City of Portland, Maine - Building or Use Permit Application
 389 Congress Street, 04101 Tel: (207) 874-8703, Fax: (207) 874-8716

Permit No: 05-0802	Issue Date:	CBL: 258 B002001
-----------------------	-------------	---------------------

Location of Construction: 456 Capisic St	Owner Name: Koutny John R &	Owner Address: 46 Northwood Dr	Phone:
Business Name:	Contractor Name: Ryan Hines	Contractor Address: 333 Bonney Eagle Rd Standish <i>04084</i>	Phone: 2076423200
Lessee/Buyer's Name	Phone:	Permit Type: Single Family	Zone: <i>R-3</i>
Past Use: vacant land	Proposed Use: Single family House / garage	Permit Fee: \$1,518.00	Cost of Work: \$158,000.00
		CEO District: 3	
Proposed Project Description: House / garage		FIRE DEPT: <input type="checkbox"/> Approved <input type="checkbox"/> Denied	INSPECTION: Use Group: Type:
		Signature:	Signature:
PEDESTRIAN ACTIVITIES DISTRICT (P.A.D.)			
Action: <input type="checkbox"/> Approved <input type="checkbox"/> Approved w/Conditions <input type="checkbox"/> Denied			
		Signature:	Date:

CHECK-LIST AGAINST ZONING ORDINANCE

MINOR SITE PLAN  
SHOWING A PROPOSED 2-STORY DWELLING  
456 CAPISIC STREET PORTLAND, MAINE

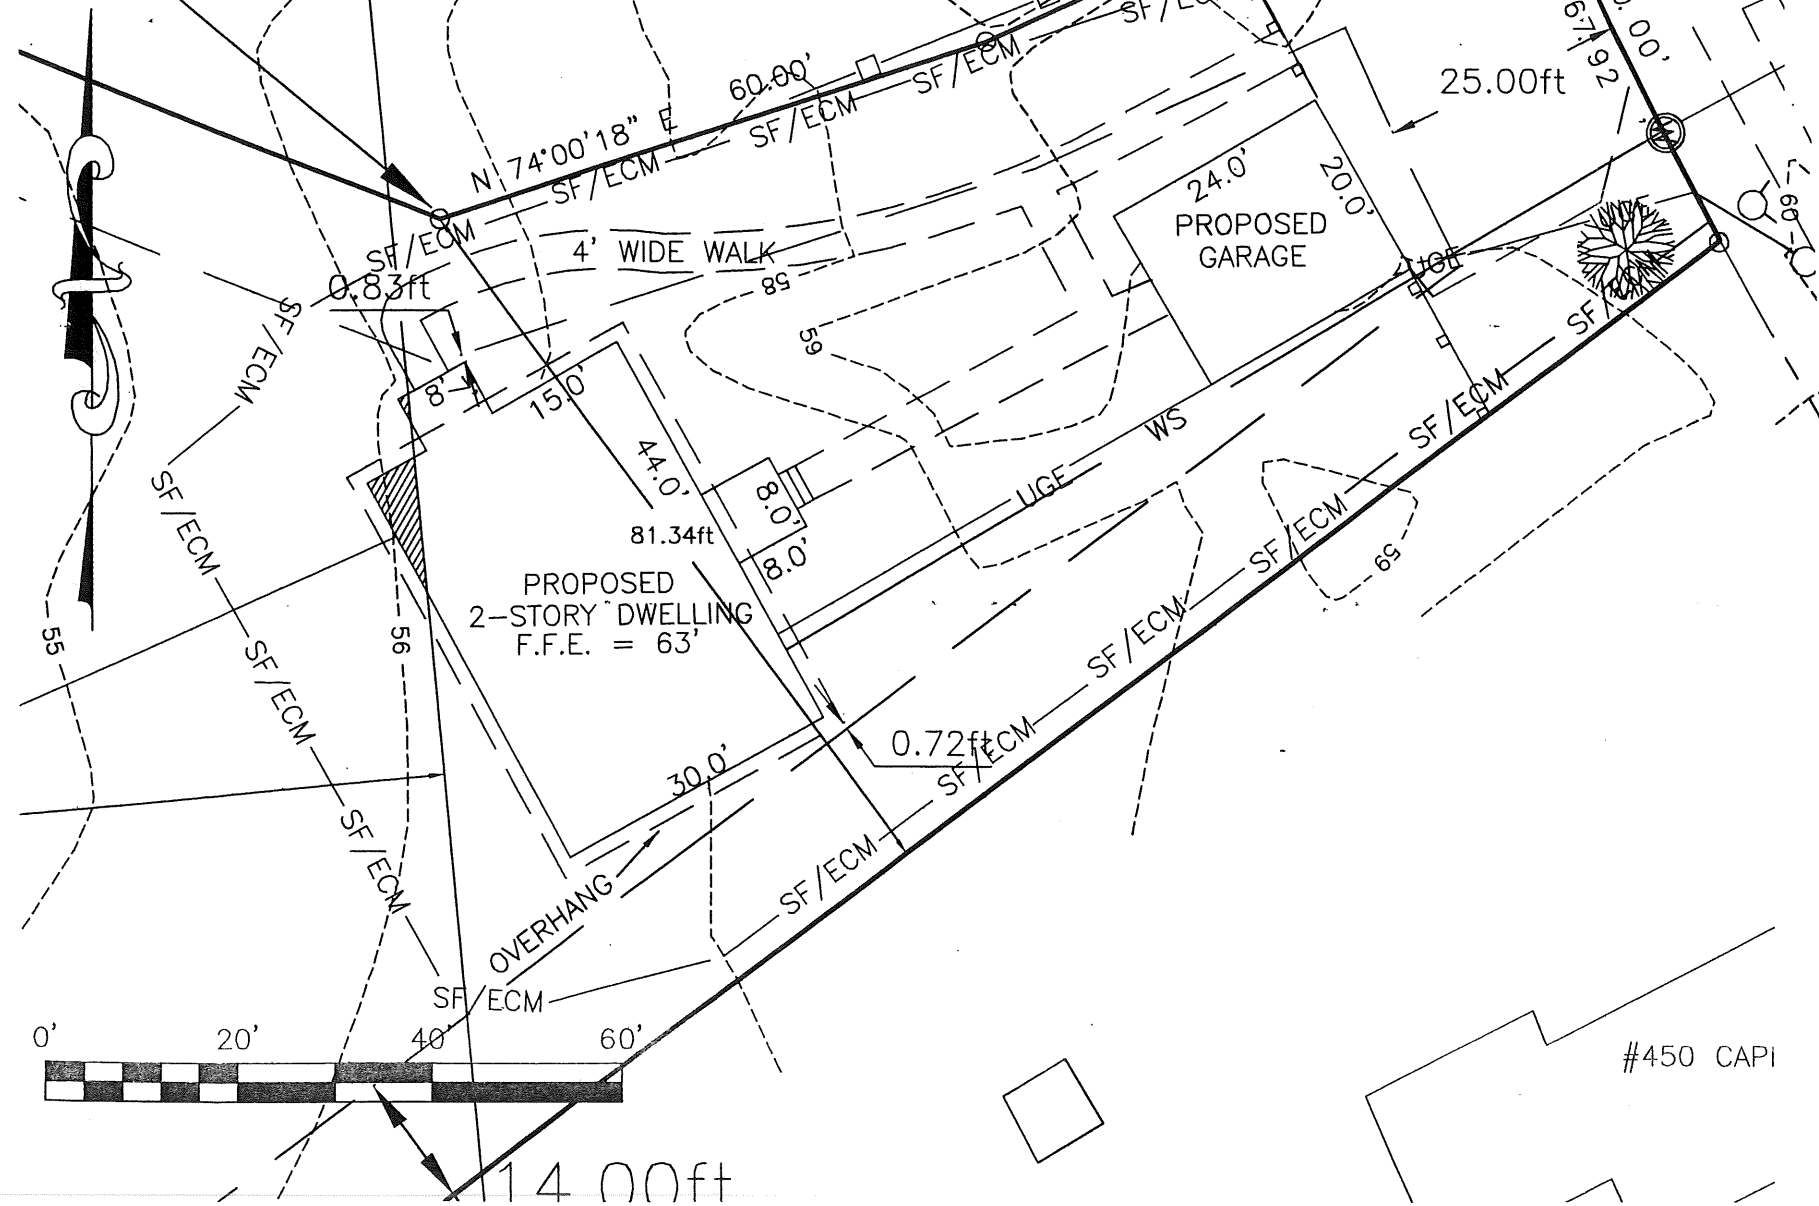
Lot Street Frontage - 50' min - 50' shown

Front Yard - 25' min - 30' scaled

Rear Yard - 25' min - 248' scaled

(75' from HWM - over 200' shown)

Side Yard - 14' min - 16' & 19' scaled

Projections - front entry - 8x8 - rt side entry - 6x8 - Detached garage 20'x24' - no rear deck shown

Width of Lot - 65' min - 79' scaled at house (principal bldg)

Height - 35' MAX - 29' for dwelling / 18' max height for garage - 12.75' scaled

Shoreland Zoning/ Stream Protection - on rear of lot - only a small portion of the house is delineated in the 250' shoreland - well over 75' from HWM.
